From: Jacqui B
To: [Robin Proebsting](mailto:Robin.Proebsting)
Cc: jerm721@aol.com
Subject: Comments on the proposed development at 2825 WMW
Date: Wednesday, May 8, 2019 4:09:28 PM

As a property owner adjacent to this proposed development, I have a few questions/concerns regarding the project:

SITE PLAN
2825 W MERCER WAY
PRELIMINARY PLAT
 PARCEL #2174502425
 CITY OF MERCER ISLAND WASHINGTON

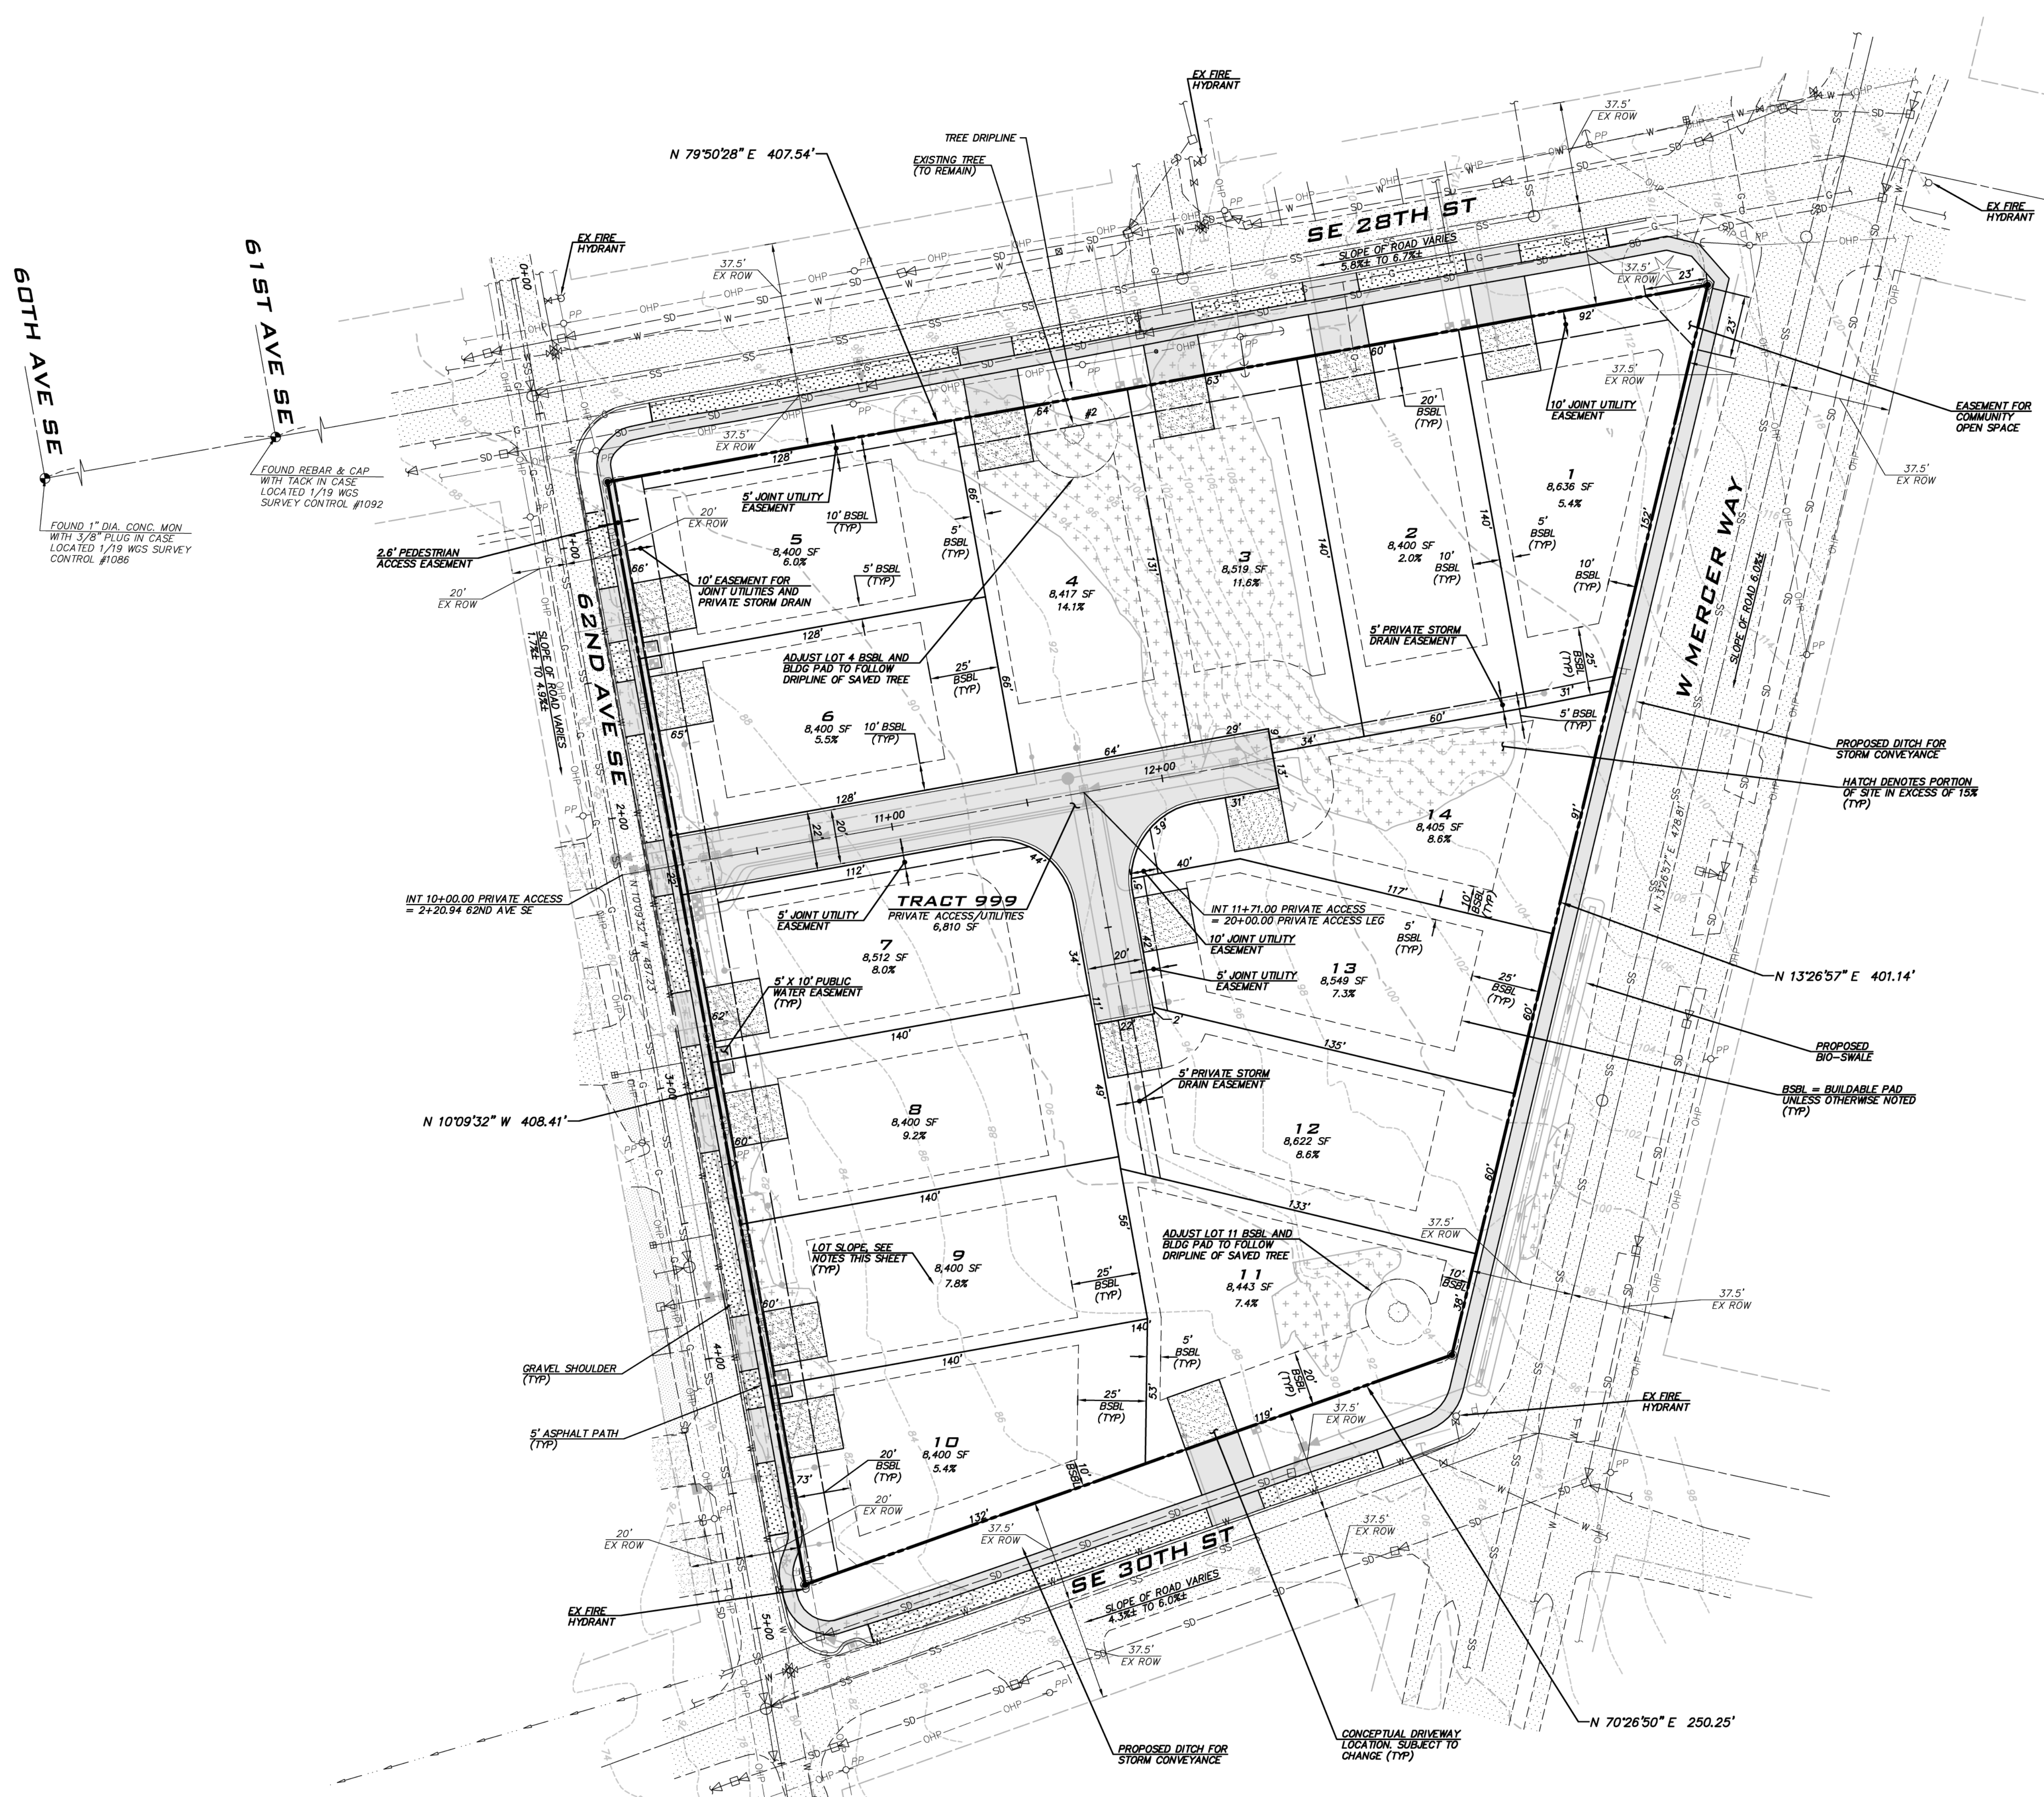
3. The schematic in the ESNW report showing the 14 lots differs from the existing neighborhood. Cramming that many individual properties into one build site conflicts with the current character of our neighborhood.

PRELIMINARY GRADING PLAN
2825 W MERCER WAY
PRELIMINARY PLAN
 PARCEL #2174502425
 CITY OF MERCER ISLAND WASHINGTON

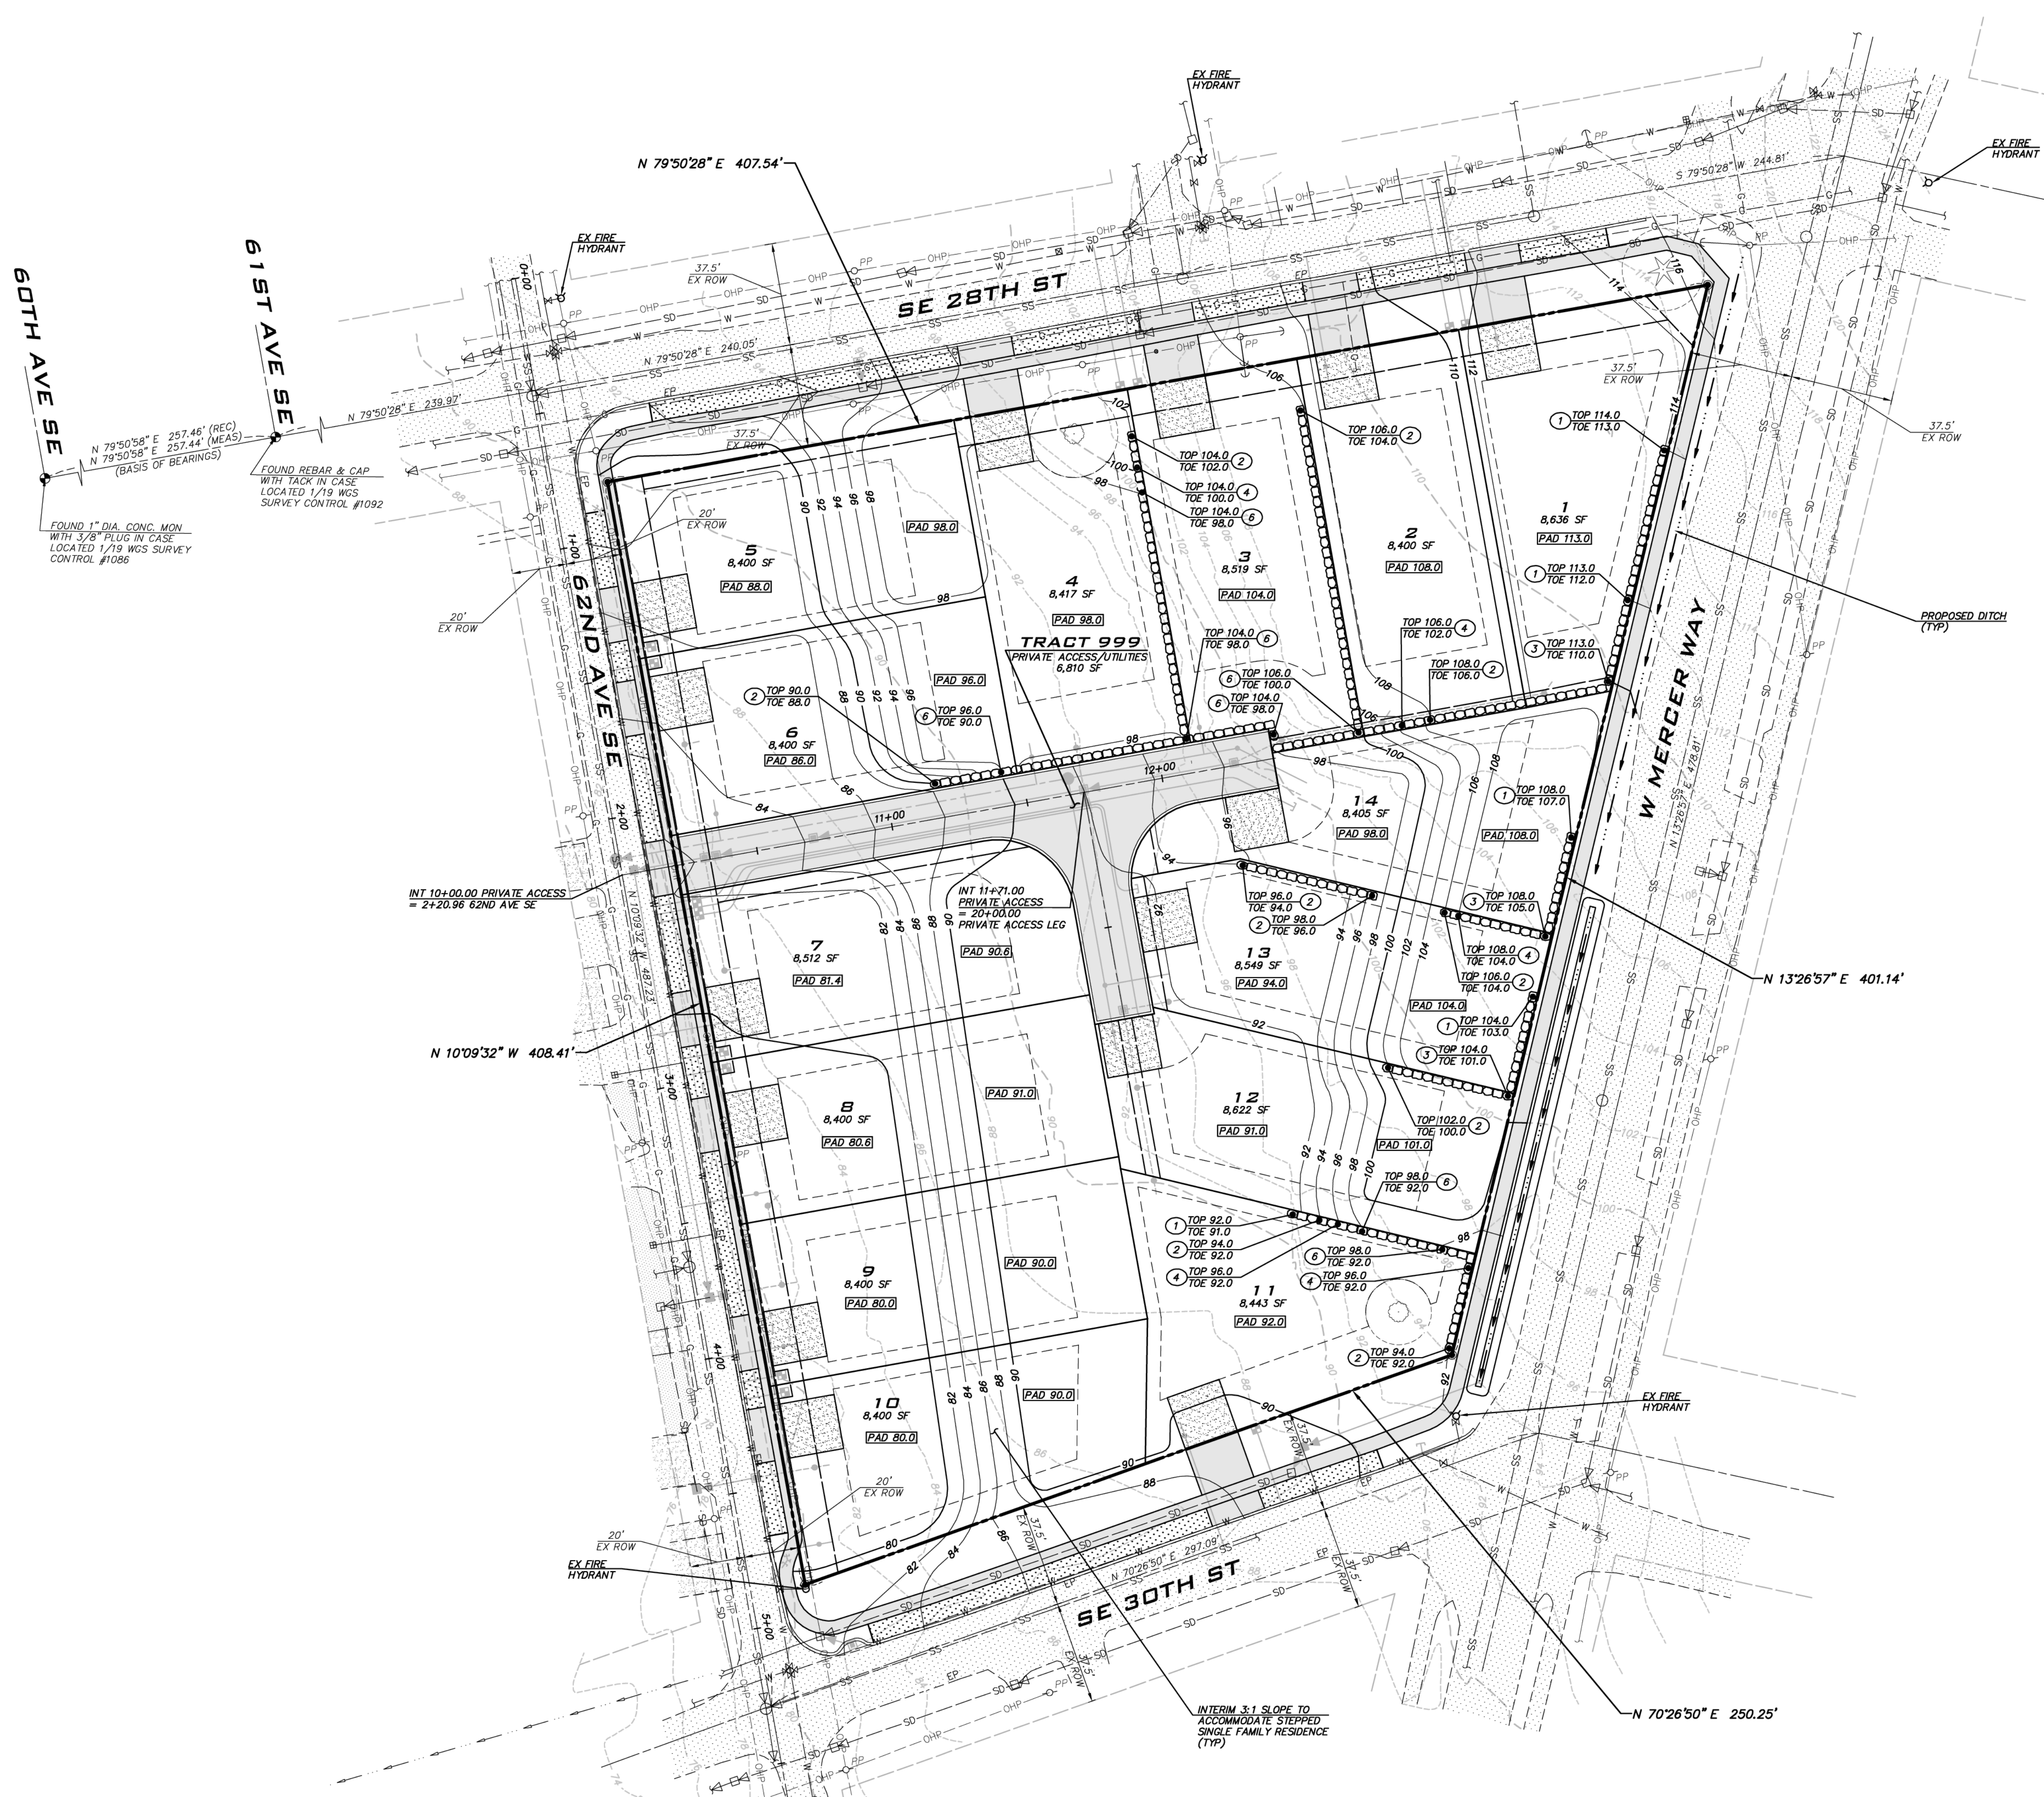
4. Due to the hilly nature of the build site, what measures will be taken for the protection of property owners downslope of the proposed clearing and construction? What pro-active steps will be taken on the job site to reduce and control erosion?

**PRELIMINARY ROAD PLAN &
SECTIONS**

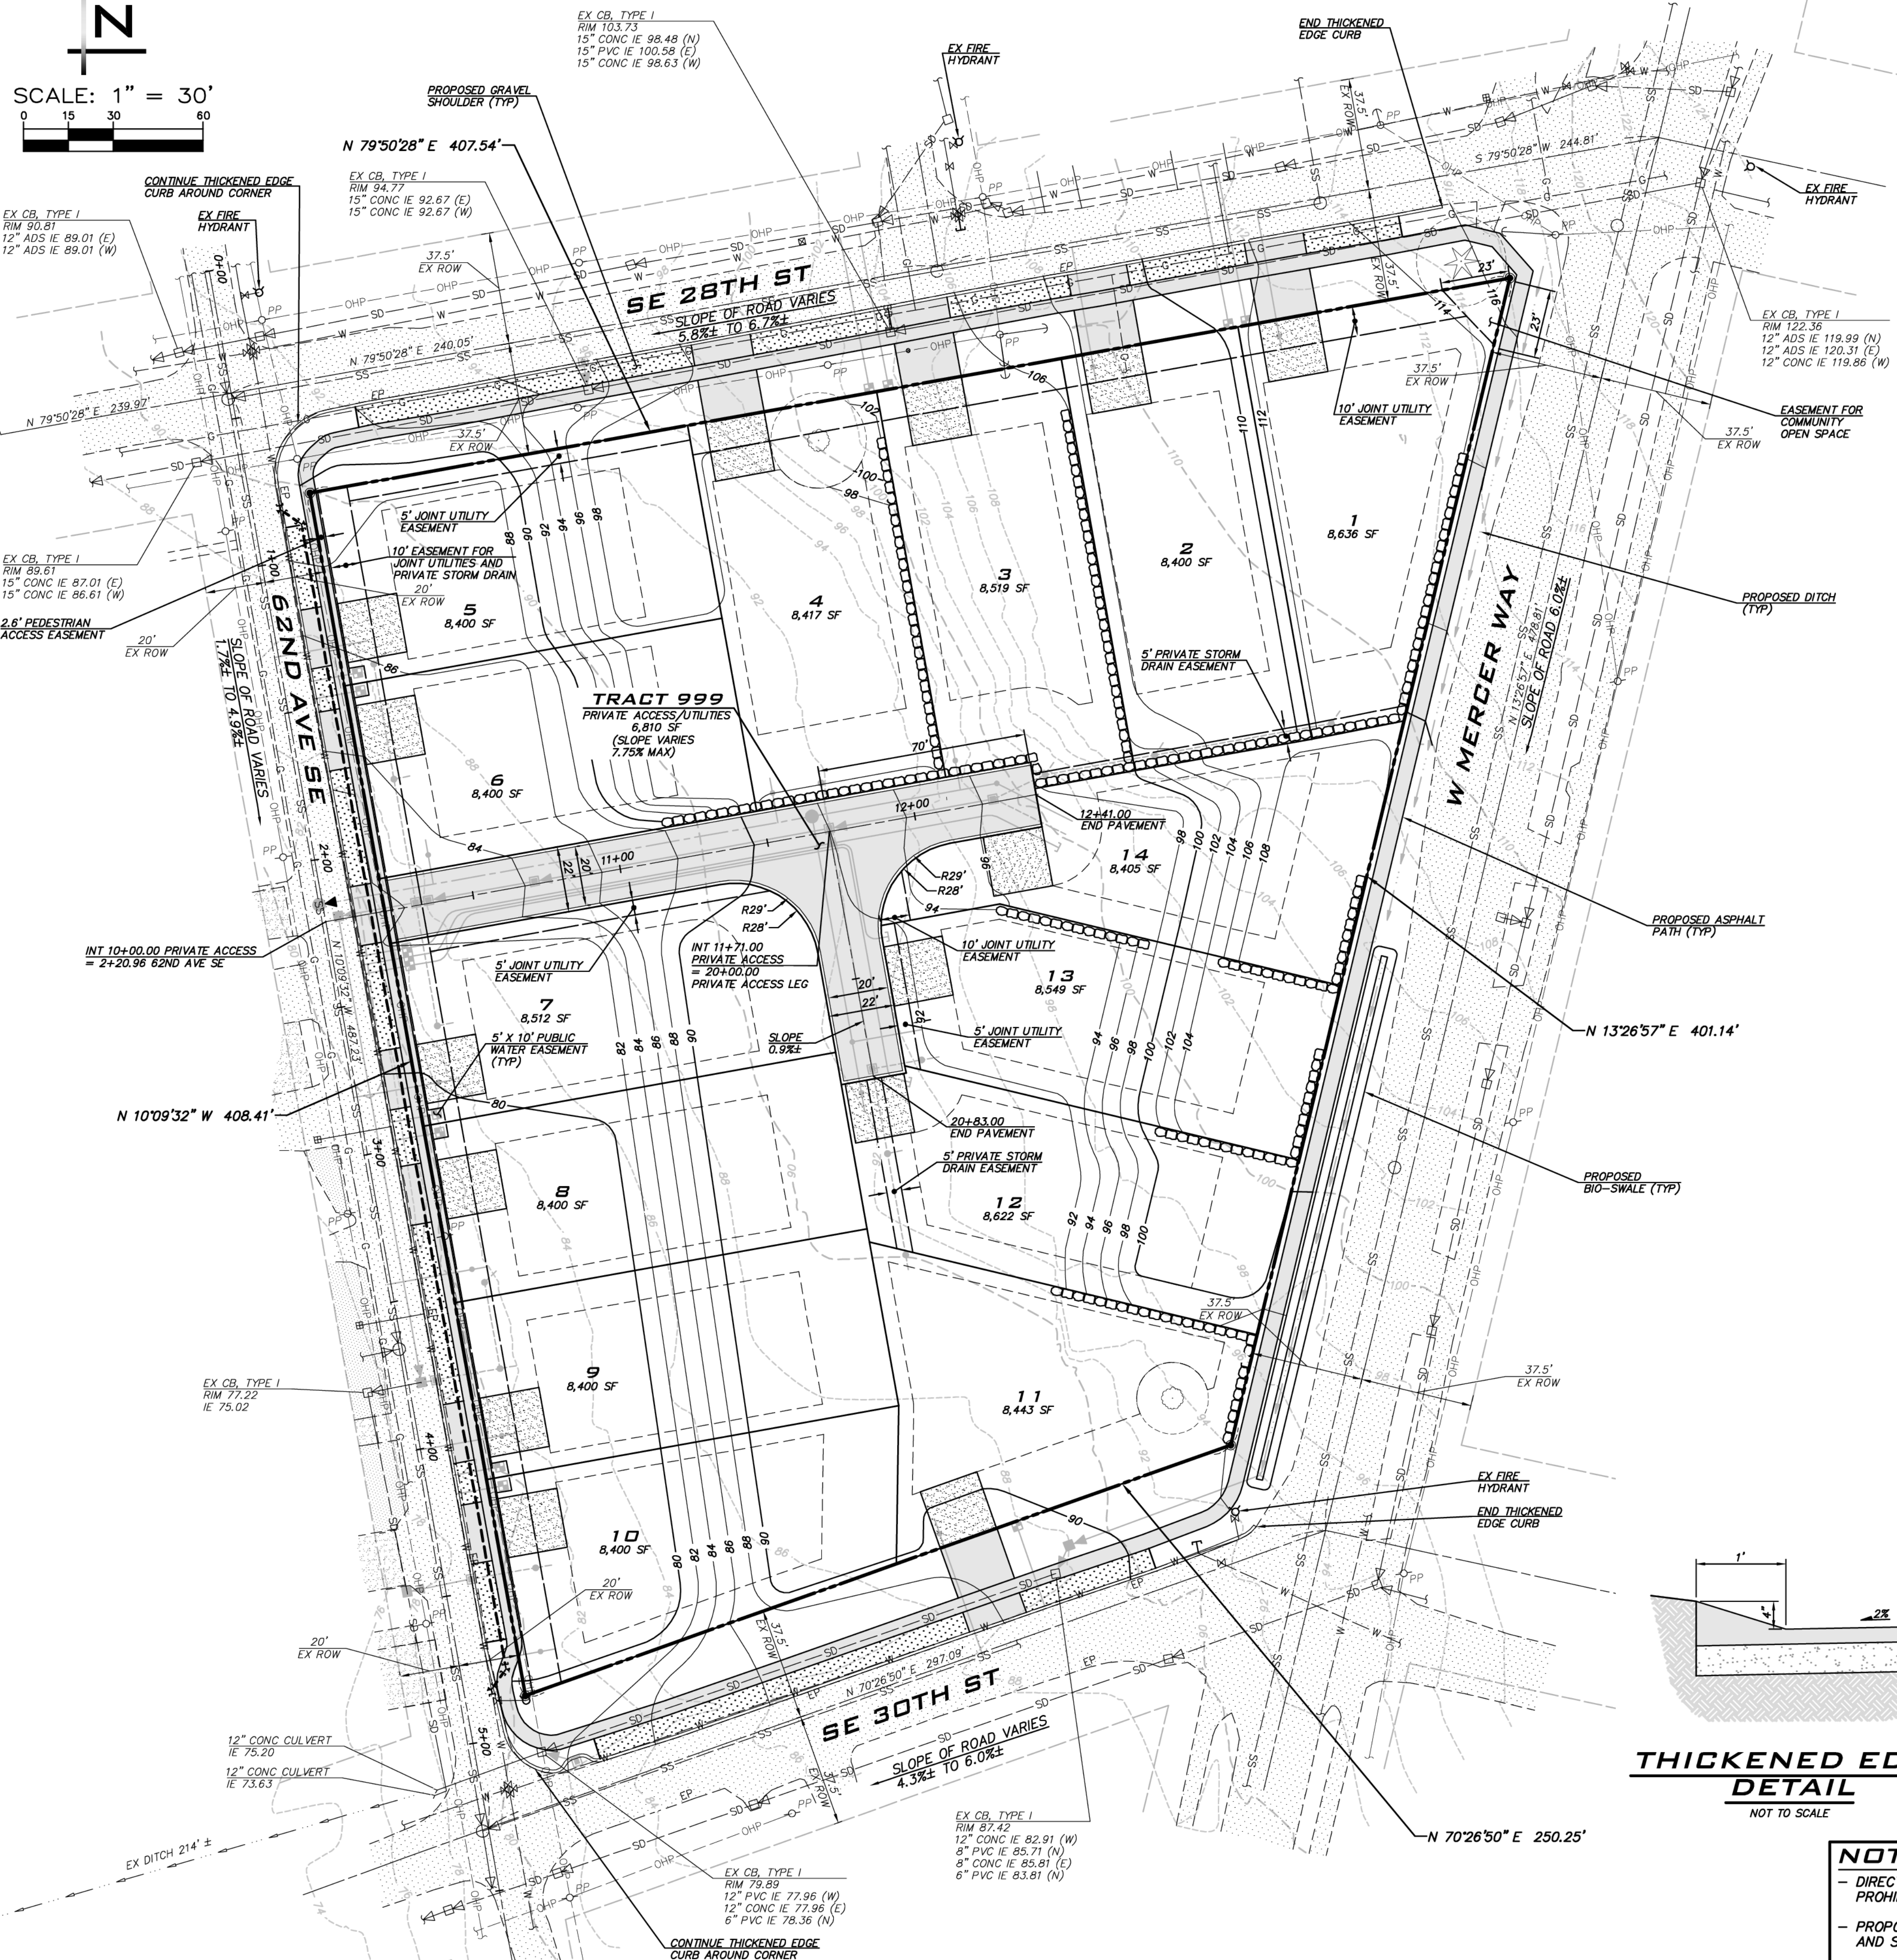
2. I am **STRONGLY** against creating the proposed private tract road that will disrupt quiet 62nd. Increased traffic will cause disruption in our neighborhood. The existing street is quite narrow and will be unable to sustain increased traffic. There are currently two access points to this property- one off of West Mercer Way, the other off of 28th. Each of those streets provide sufficient access to the property and are capable of accommodating two way traffic.

14. If 62nd needs to be widened under the proposed plan, will the street widening project encroach onto land of private property owners on the west side of the street. If so, how will those property owners be compensated and how will it impact the ability of those property owners to make structural changes (remodels/additions) in the future?
